LAND TECHNOLOGIES, INC.

Response to Comments

Project Name: Undi Commerce Park
 Project File Number: PA22008 Technical Review 1
 Review Completion: April 27, 2022

Sheet Title:
**OVERALL
 SITE PLAN**

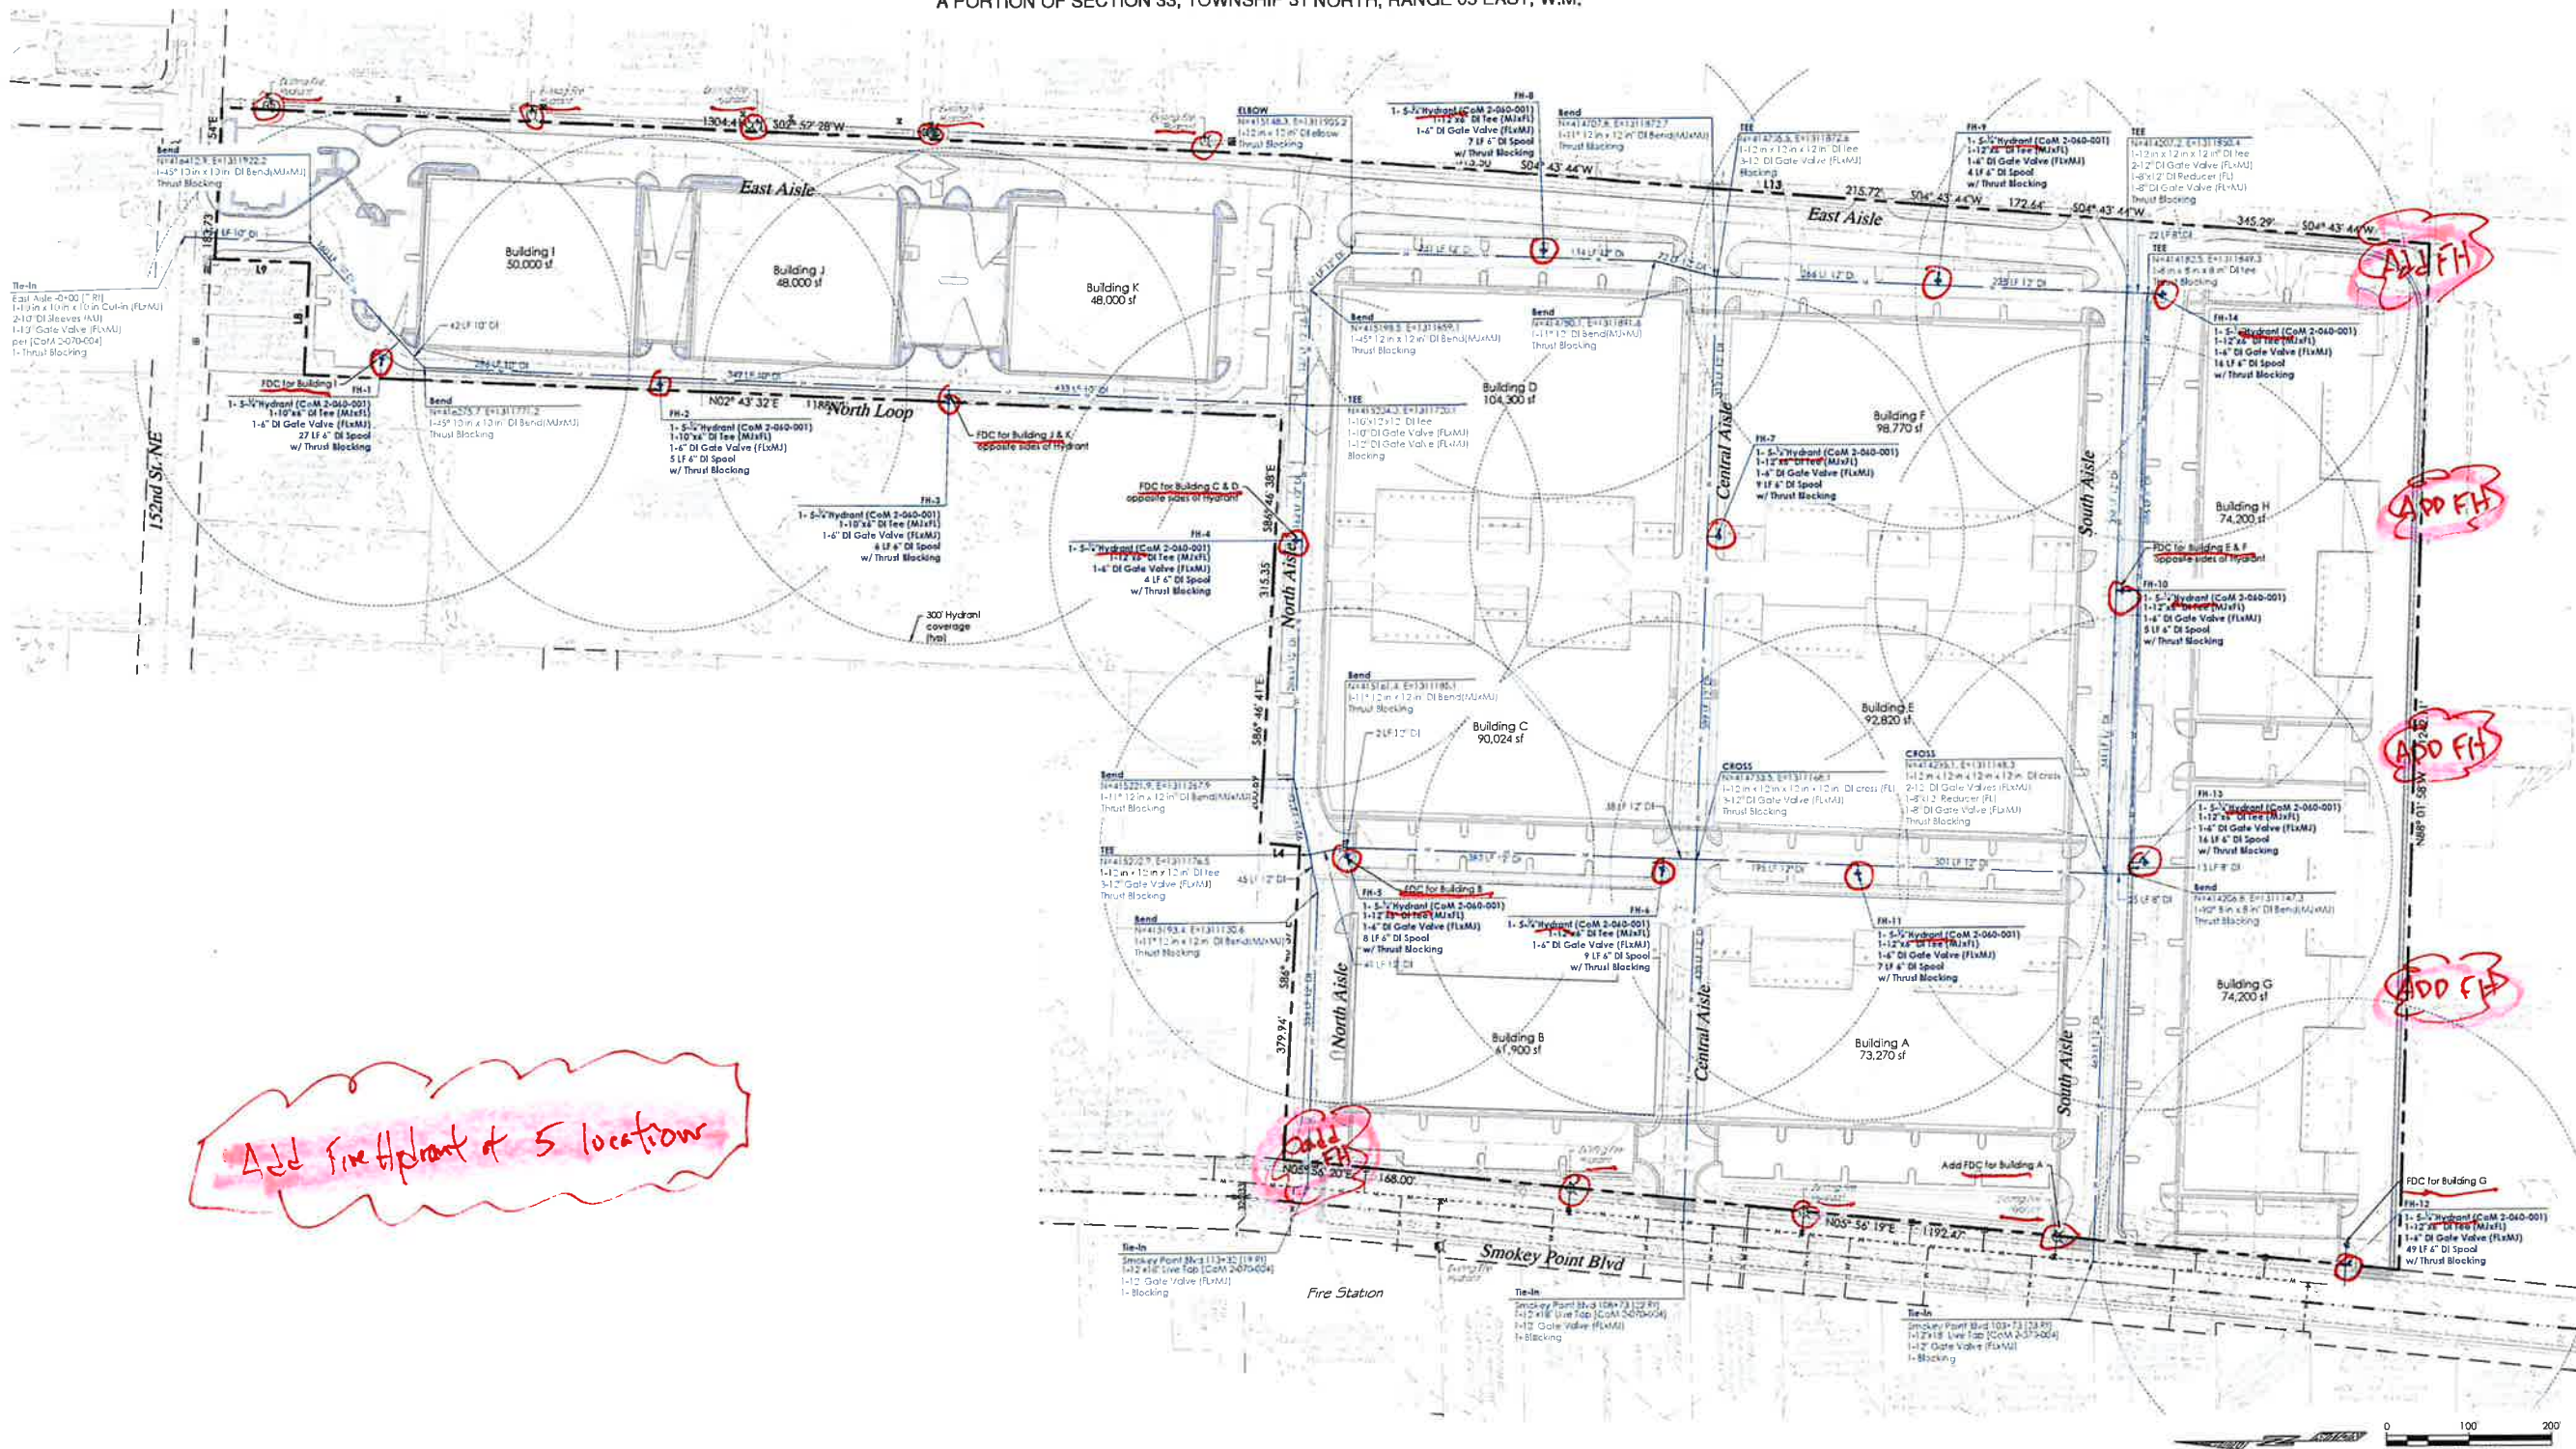
<p>5. Sheet A0.1 - Overall Site Plan, shall be amended, as follows:</p> <ul style="list-style-type: none"> a. Pursuant to MMC 22G.120.060(3)(b), provide additional sheets at a reviewable scale (i.e. 1" = 20', 1"= 30', 1"= 40' or 1" = 50'). b. The site plan shall be revised to comply with EDDS 3.301 <i>Arterial Access Management Standards</i>. See attached comments from Kacey Simon, Civil Plan Reviewer, dated April 14, 2022 and Jesse Hannahs, PE, Traffic Engineering Manager, dated April 27, 2022. c. Provide storage space and collection points for recyclables in accordance with MMC 22C.020.320. Additionally, note the required SF calculations on the site plan, including area provided. This is in addition to the solid waste collection areas below. Collection areas are required to be paved with concrete and screened with a minimum 6' high enclosure constructed of concrete block or brick, in addition to the landscaping provisions outlined below. d. Provide collection points for solid waste. 	<ul style="list-style-type: none"> a. See arch plans for scale meeting the example listed. Future civil construction plans will be at a scale appropriate for construction and will be maximized for constructability and readability. (i.e. 50-scale or 'less') For broad site planning and overall function of the entire site, scale less than required to show the entirety of the site does not lend to legibility of the overall site and flow. b. Access locations have been revised following meeting with City staff. (Access and site 'flow' review is facilitated with plan scale showing entire site on single sheet.) c. See arch plans.

<ul style="list-style-type: none"> • <u>This structure is to provide Premise identification:</u> Address to be posted visible from the street with min. 6-8 inch contrasting numbers per IBC 501.2 	<p>Thank you</p>
<ul style="list-style-type: none"> • Building application for plan review will be approximately 6-8 weeks for first-time plan review comments. 	<p>Thank you.</p>
<p>Plansheet Comments:</p>	
<p>On Architect’s sheet A0.1, “Provide fire access through these two locations.”</p>	<p>Thank you.</p>

sheet
A1.2

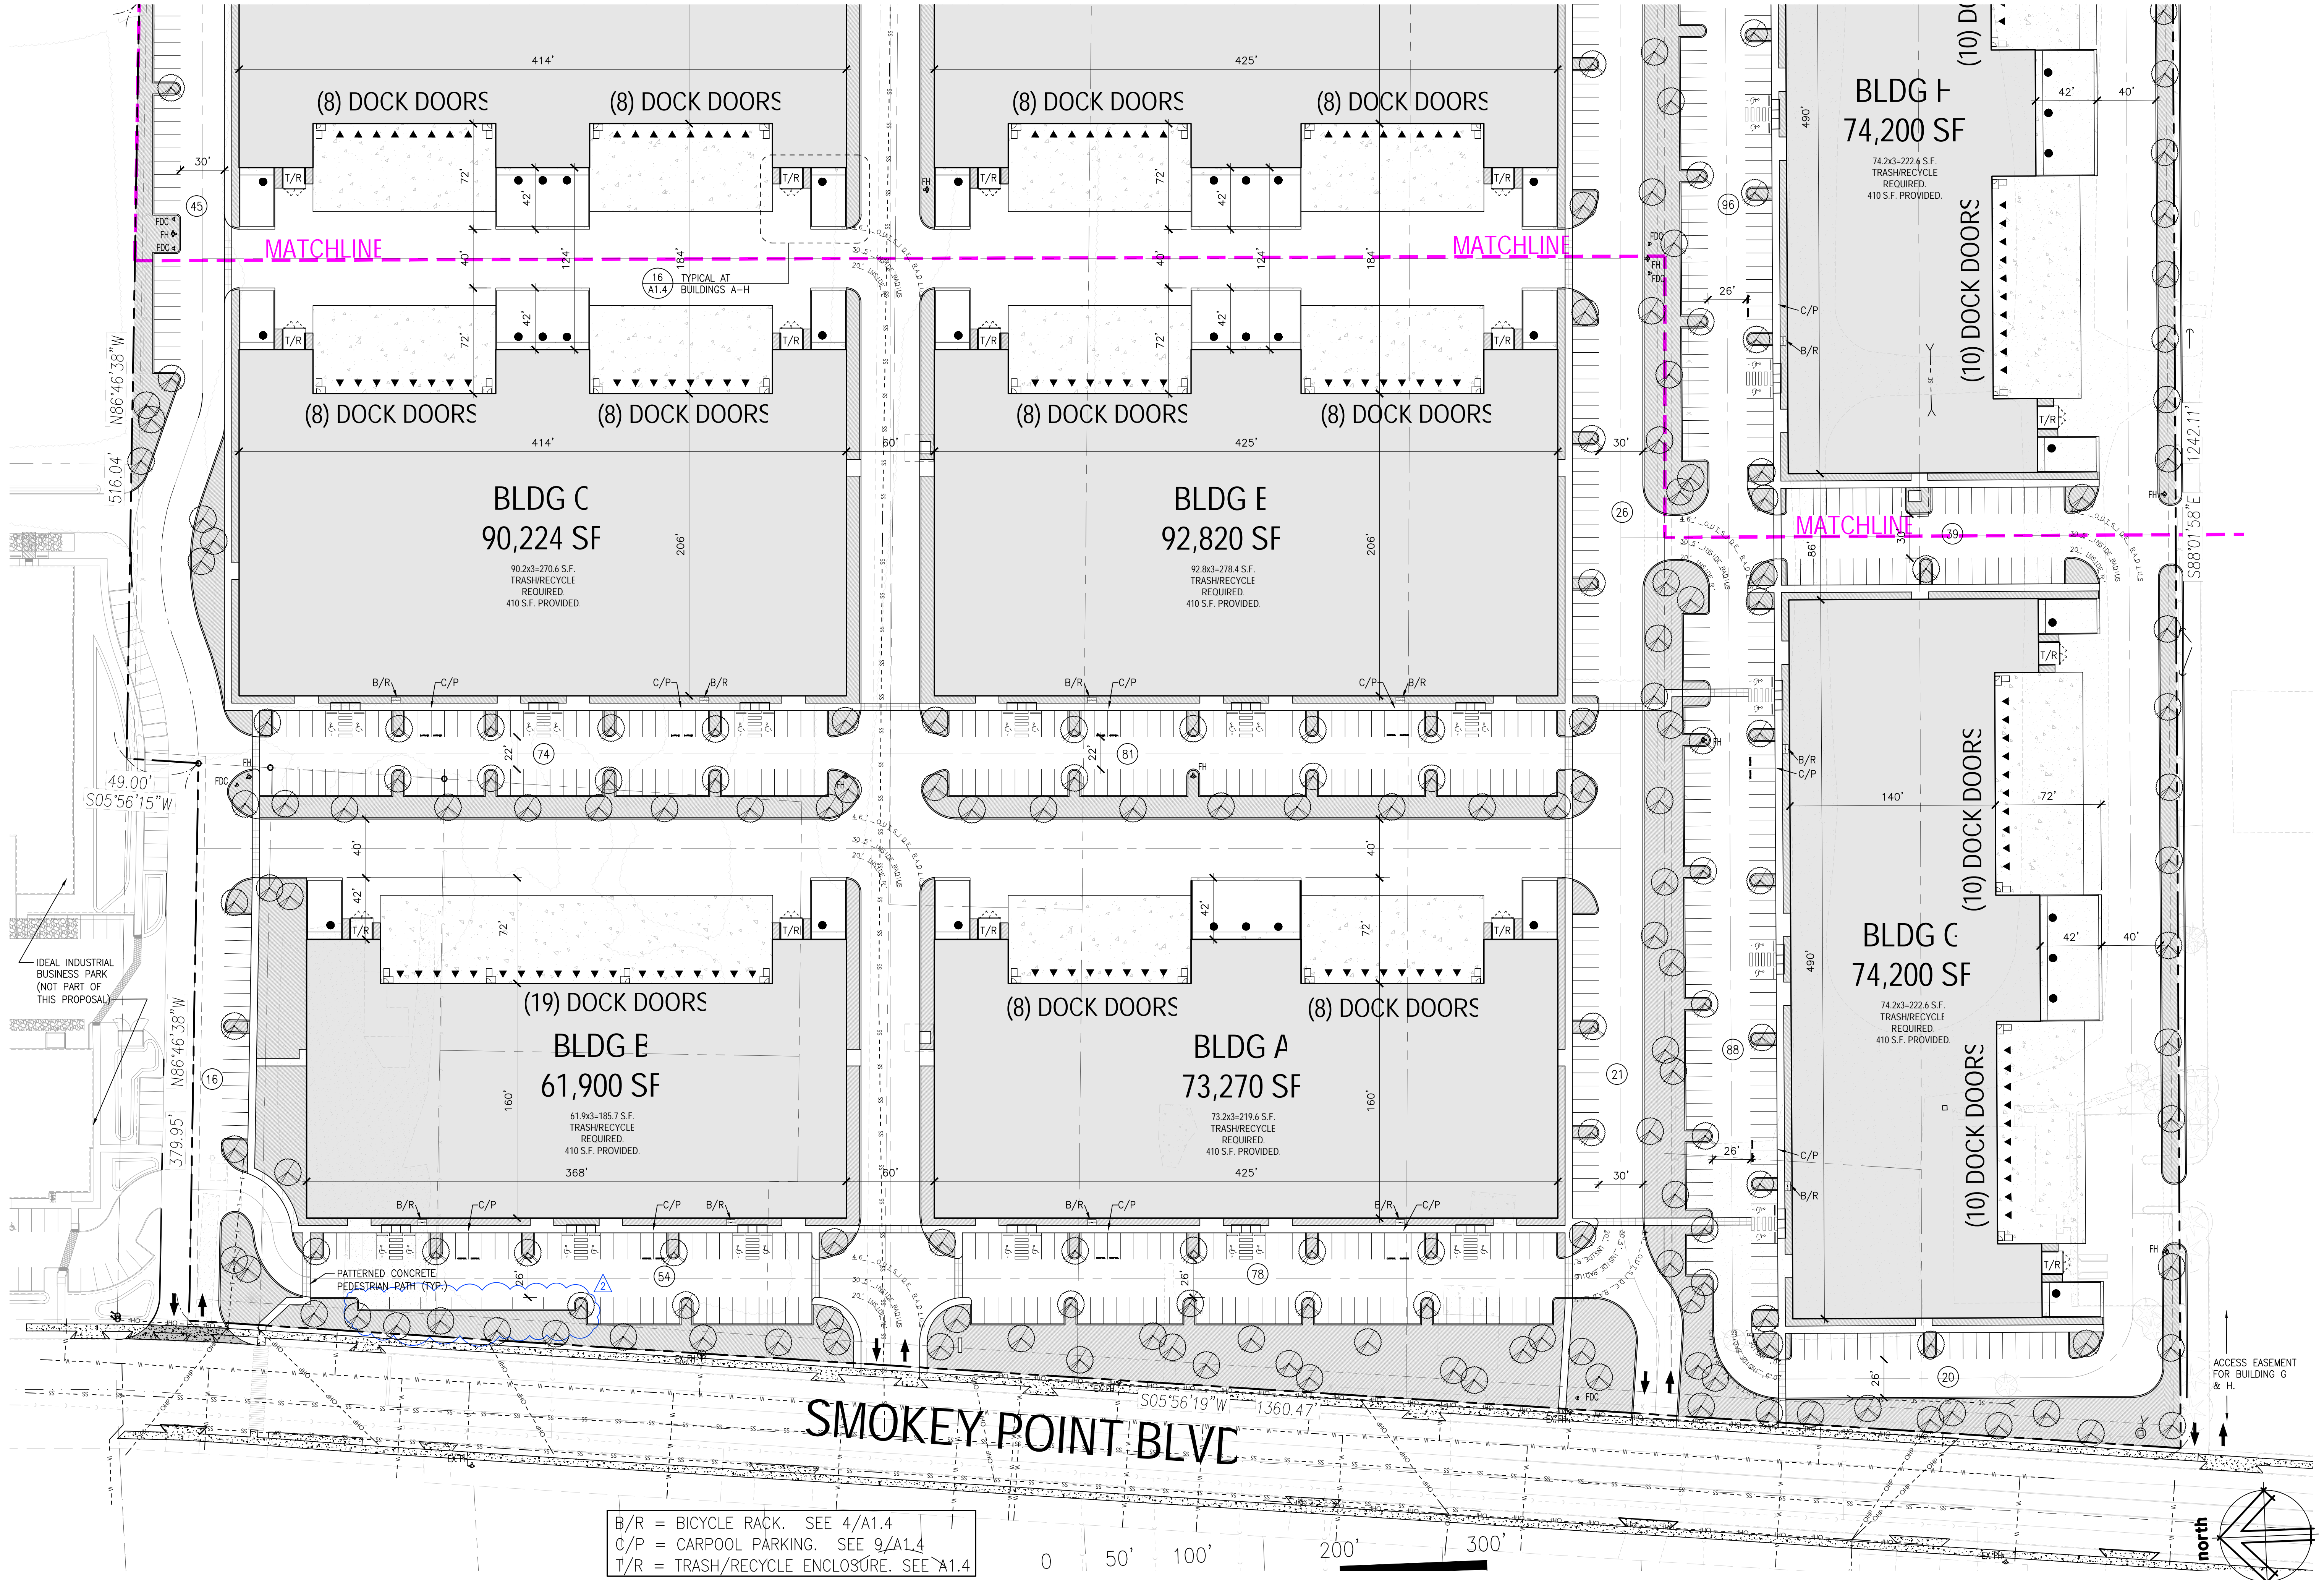
CITY COMMENTS	LAND TECH RESPONSE
<p>Contact Skip Knutsen, Public Works Service Manager, at 360.363.8173 or sknutsen@marysvillewa.gov, for solid waste collection area dimensional and location criteria.</p> <p>Collection areas are required to be paved with concrete and screened with a minimum 6' high enclosure constructed of concrete block or brick, in addition to the landscaping provisions outlined below.</p> <p>e. Thank you for referencing the minimum turning radii on the site plan. Depict actual turning radii proposed on site plan.</p> <p>f. Provide an auto-turn exhibit showing that the largest trucks navigating through the site will not damage any vertical curbs and landscape islands.</p> <p>g. Additional pedestrian connections traversing the proposed drive-aisles and in some instances landscape buffers, shall be provided per the attached redlines</p> <p>Pedestrian pathways are required to be constructed with decorative concrete clearly denoting the pedestrian pathway. The pathways must be universally accessible and meet ADA standards. This detail shall be required to be provided on the civil construction plans.</p> <p>h. Provide carpool parking locations and calculations in accordance with MMC 22C.130.030(3).</p> <p>i. Provide a detail of the required carpool parking signage. Signs must be posted indicating these spaces are reserved for carpool use before 9:00 a.m. on weekdays.</p> <p>j. Provide bicycle parking locations and calculations in accordance with MMC 22C.130.060.</p>	<p>d. See arch plans</p> <p>e. Actual turning radius along curb line, centerline, and outside curb have been added to sheet C1 for demonstration of turning radius on select corners within the development.</p> <p>f. An auto-turn exhibit has been added as sheet C9.</p> <p>g. See Arch Response “Pedestrian connections have been added to the site plan per the marked up plans provided in review #1. All buildings are interconnected, and access is provided at multiple locations along 152nd Street NE and Smokey Point Boulevard. Pedestrian access through al drive aisles will be concrete with a decorative pattern.”</p> <p>h. See Arch response “Carpool parking calculations have been provided on sheet A1.1 under SITE INFORMATION. Carpool parking locations have been added around all buildings as required by MMC 22C.130.030(3). Provided carpool parking is greater than required for all buildings.”</p>
